**Date:** 01/10/2024

**Re:** **Tray Ceiling Issue**  
Location: Lot 161 The Farm at Neill:p:s Creek (Lillington, NC)  
JDS Project No.: RDU2400265  
Date of Inspection: 1/10/24

Drawing file: SFD2311-0048 / 161 Floor Layout.pdf

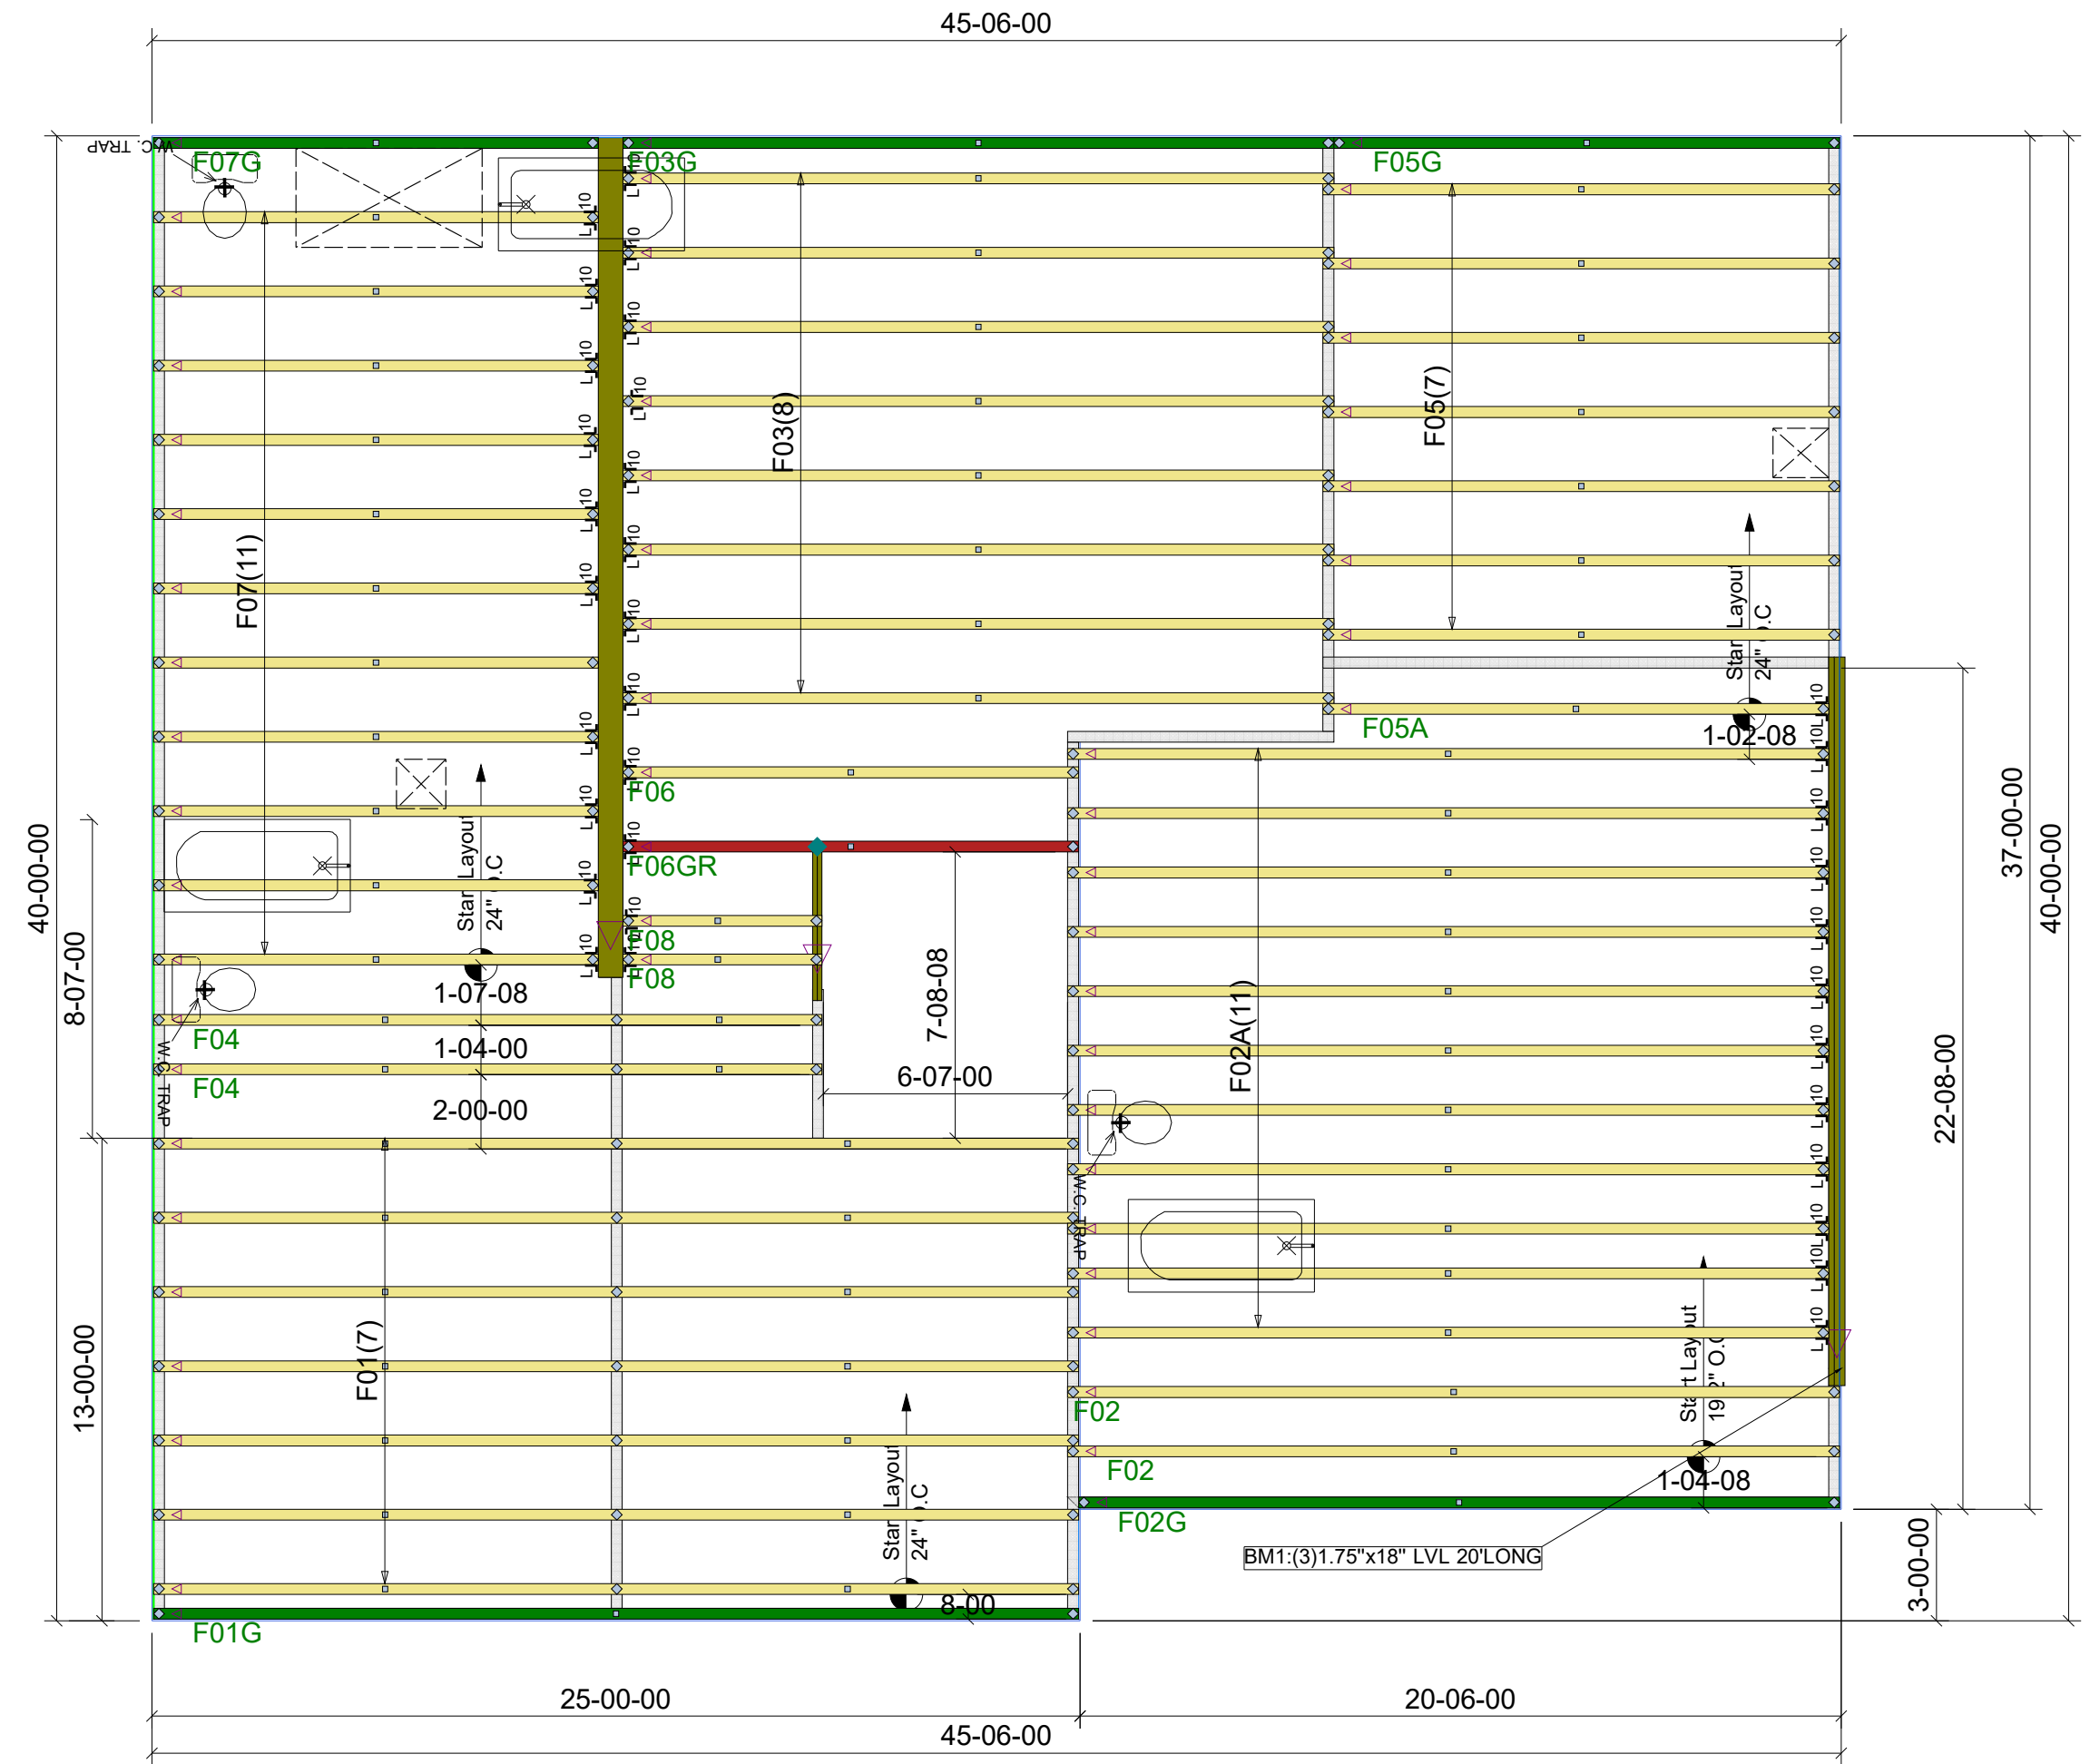
The client has requested evaluation of the 6<sup>th</sup>-15<sup>th</sup> trusses from the right which need to be modified to allow for a tray ceiling. The trusses needing modification are as follows: (5) A01 trusses, (4) A03 trusses and (1) A03H truss. The tray ceiling is set to start approximately 2' off each wall of the master bedroom until the jut out of the room begins.

- 1<sup>st</sup> cut out the truss bottom chord section to allow for the desired ceiling tray width.
- Then install (1) vertical member at each bottom chord spanning tightly between the bottom chord and top chord.

- Between the newly placed vertical members place a new horizontal member tightly between them allowing for the desire tray height.
- Cut back the current diagonal members to fit tightly atop the newly placed horizontal member.

- Install (1) 36" W x 24" H by 7/16" OSB scab on each side of each bottom chord joint centered on the joint and flush with the bottom of the original bottom chord. Attach the OSB scabs with construction adhesive and (2) rows of 6d nails 3" O.C. into every covered member. The contractor may notch the scab to fit the tray ceiling shape.

- Where the newly placed vertical members join the top chord install (1) 16" x 16" by 7/16" OSB scab on each side of each joint centered on the joint. Attach the OSB scabs with construction adhesive and (2) rows of 6d nails 3" O.C. into all covered members.

- Where the newly placed horizontal member meets the cut back diagonal members install (1) 24" x 24" by 7/16" OSB scab on each side centered on the joint and flush with the bottom of the horizontal member. Attach the OSB scabs with construction adhesive and (2) rows of 6d nails 3" O.C.
